July 30, 2020

Richard Stevenson
Tierra West LLC
5571 Midway Park Pl.
Albuquerque, New Mexico 87109

RE: Water and Sanitary Sewer Serviceability Letter #200506
Project Name: Wintergreen Apartments
Project Address: 10820 Golf Course Rd. NW
Legal Description: TR E-1 PLAT OF TRS D-1, E-1 AMAFCA BLACK
ARROYOCHANNEL ROW PARADISE HEIGHTS UNIT 1 CONT 8.7795 AC
UPC: 101206651442411302
Zone Atlas Map: A-12

ENGINEER'S SEAL	WINTERGREEN LUXURY APARTMENTS	DRAWN BY BF
		10820 GOLF COURSE RD. NW	DATE 2/15/2021
		CONCEPT MASTER UTILITY PLAN	2020013_MUB
			SHEET # C3
		5571 MIDWAY PARK PLACE NE ALBUQUERQUE, NM 87109 (505) 858-3100 www.tierrawestllc.com	JOB # 2020013

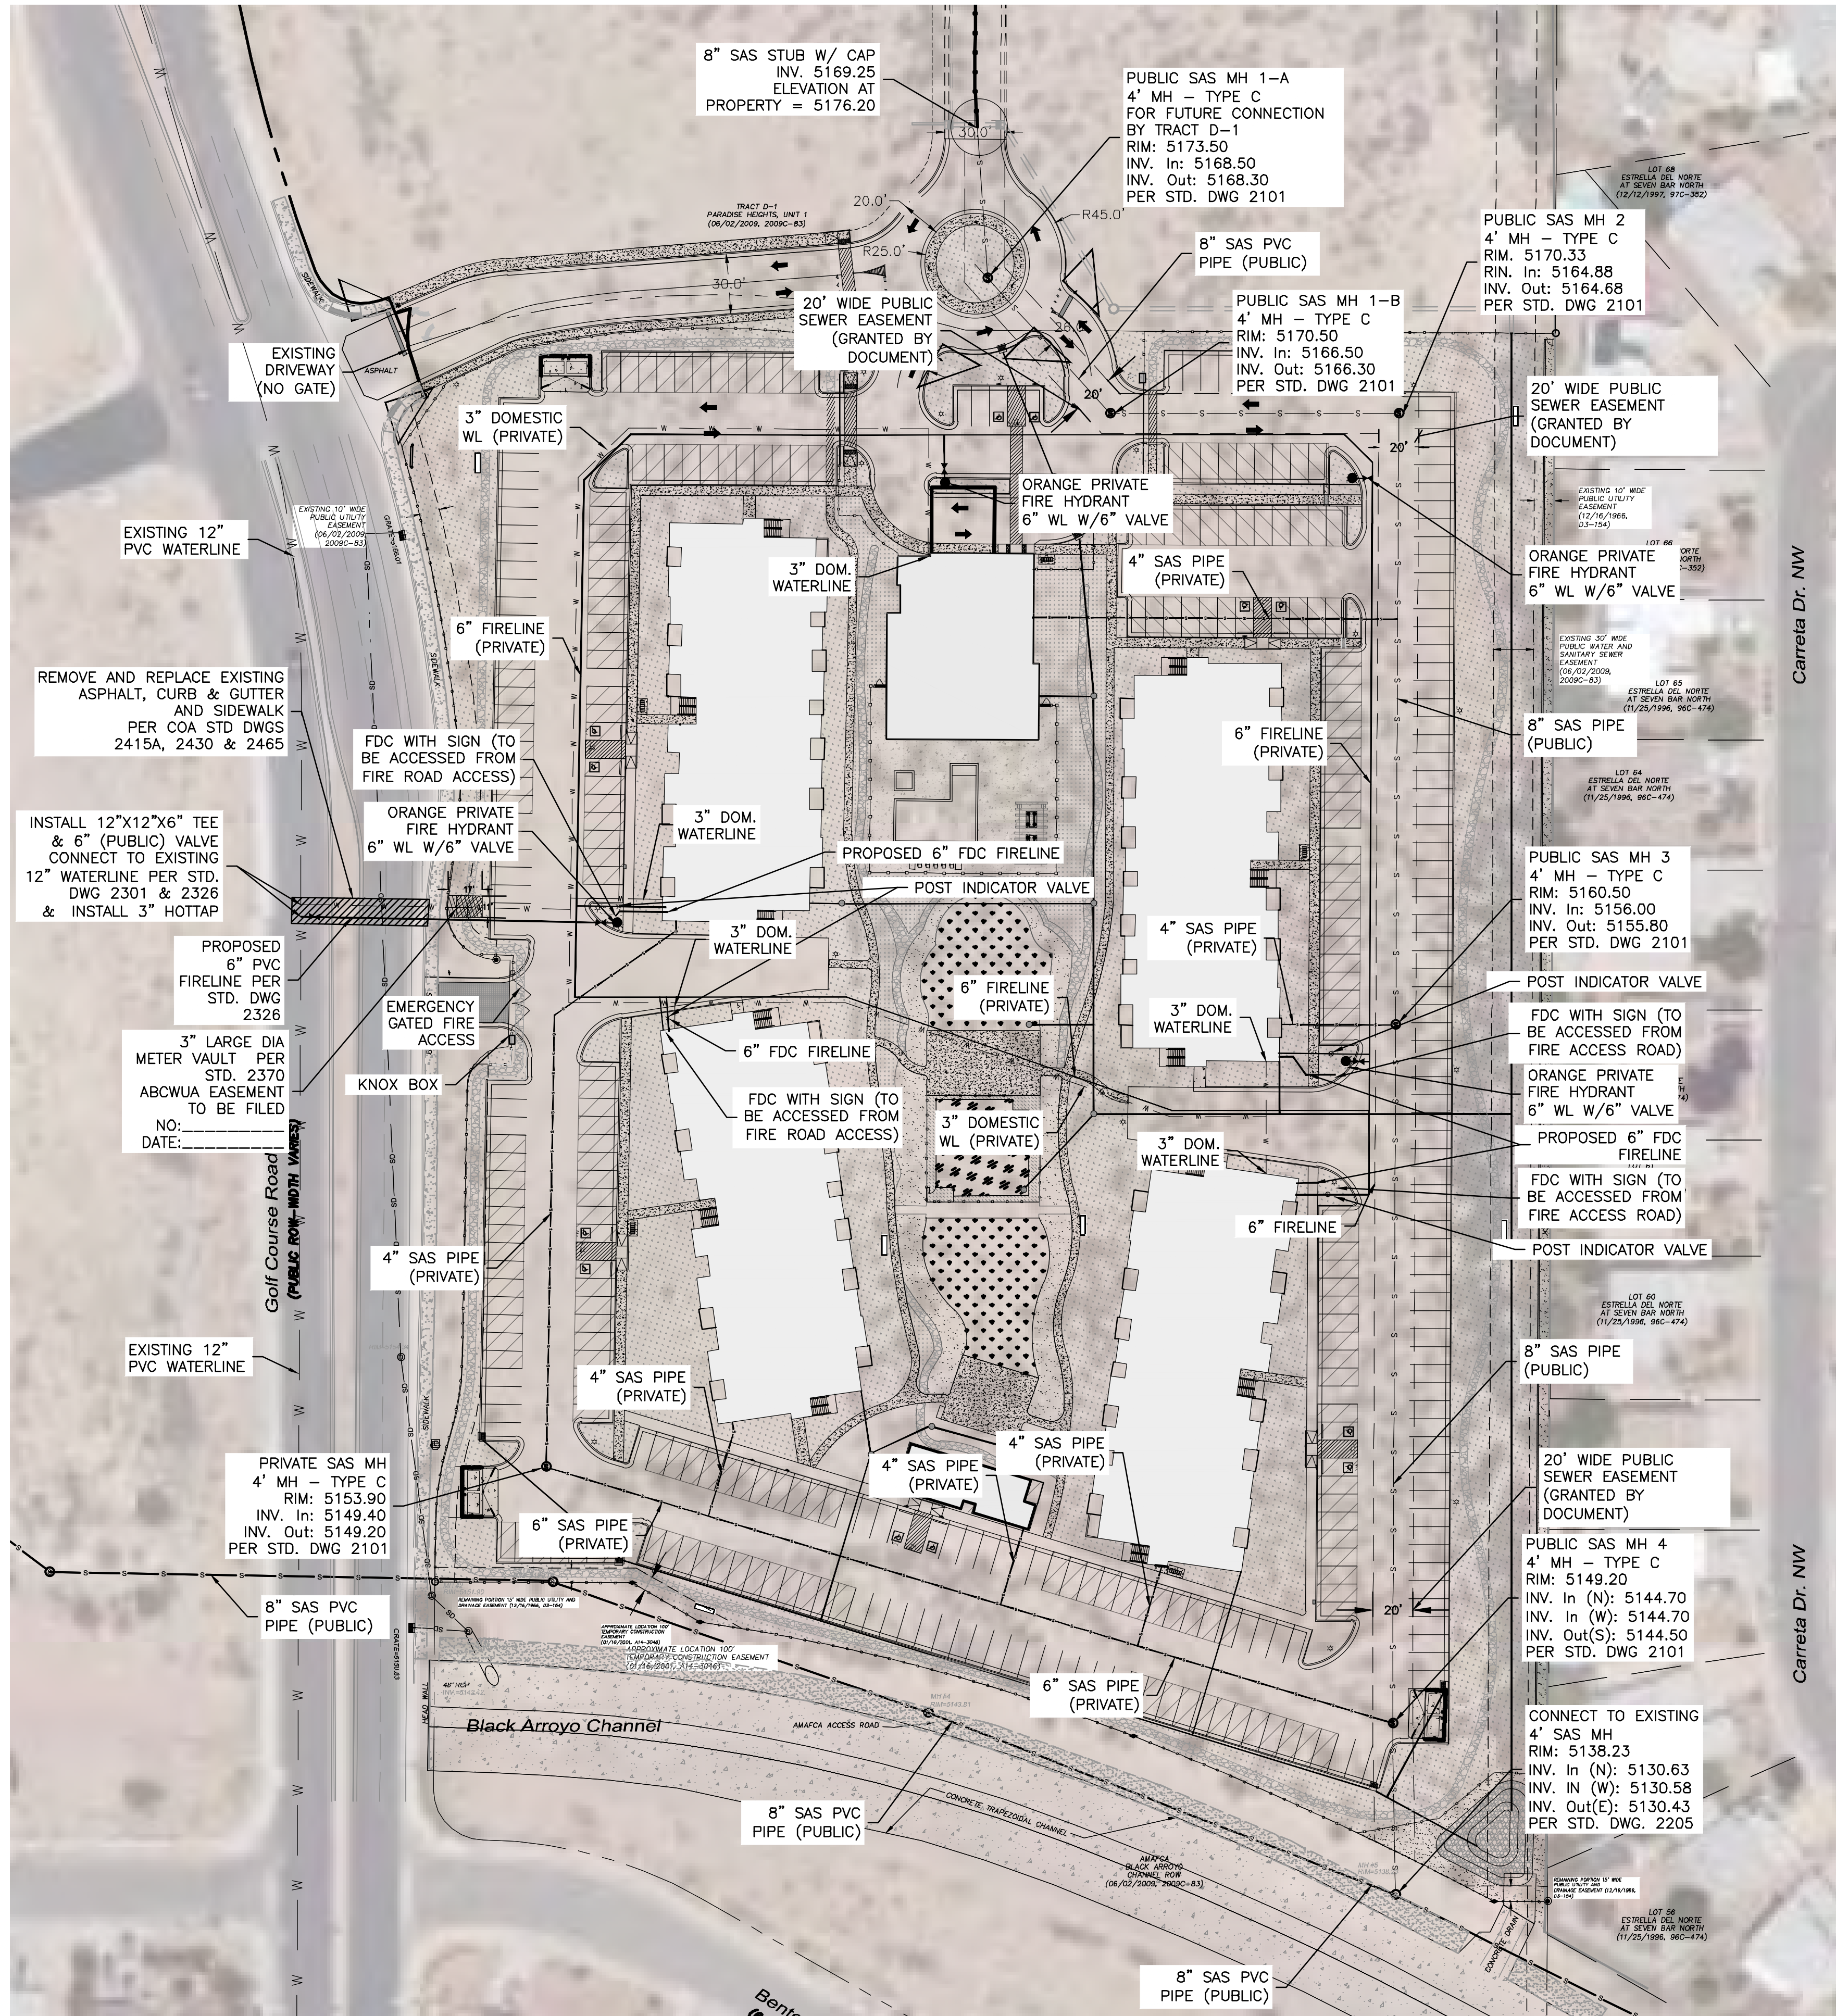
From the Utility Plan, provided as supplemental information to the request, it is understood that four private hydrants off of a private fire line that is looped to the public distribution main along Golf Course Rd., is proposed. While the private hydrants to be utilized by the site are condoned, the looped fire line is prohibited unless Water Authority approved backflow prevention devices are installed just downstream of the proposed connections to the public waterline and prior to any looping or branching. A preferred option would be to have a single connection point for the proposed fire line.

In addition to the utility improvements being proposed for the site it is to be noted that existing metered service and fire lines that will not be utilized are to be removed by shutting the valve near the distribution main and capping the line near the valve. For fire lines, the valve access shall be grouted, and collar removed.

Sanitary Sewer Service: Sanitary sewer service is contingent upon a developer funded collector line extension from the existing collector line along the site's south property border. The extension shall be along an alignment conducive to operation and maintenance post site development (preferably within a drive isle) and shall be the length required to facilitate service to lot D-1, to the north. From supplemental information, related to the site, it is understood that the existing easement onsite may not currently coincide with a proposed drive isle for the site. For a case such as this the easement may need to be vacated and a new easement granted to better adhere to the proposed development. Extension along the existing easement is not desired as operation and maintenance may prove more difficult given that this area will be for landscaping.
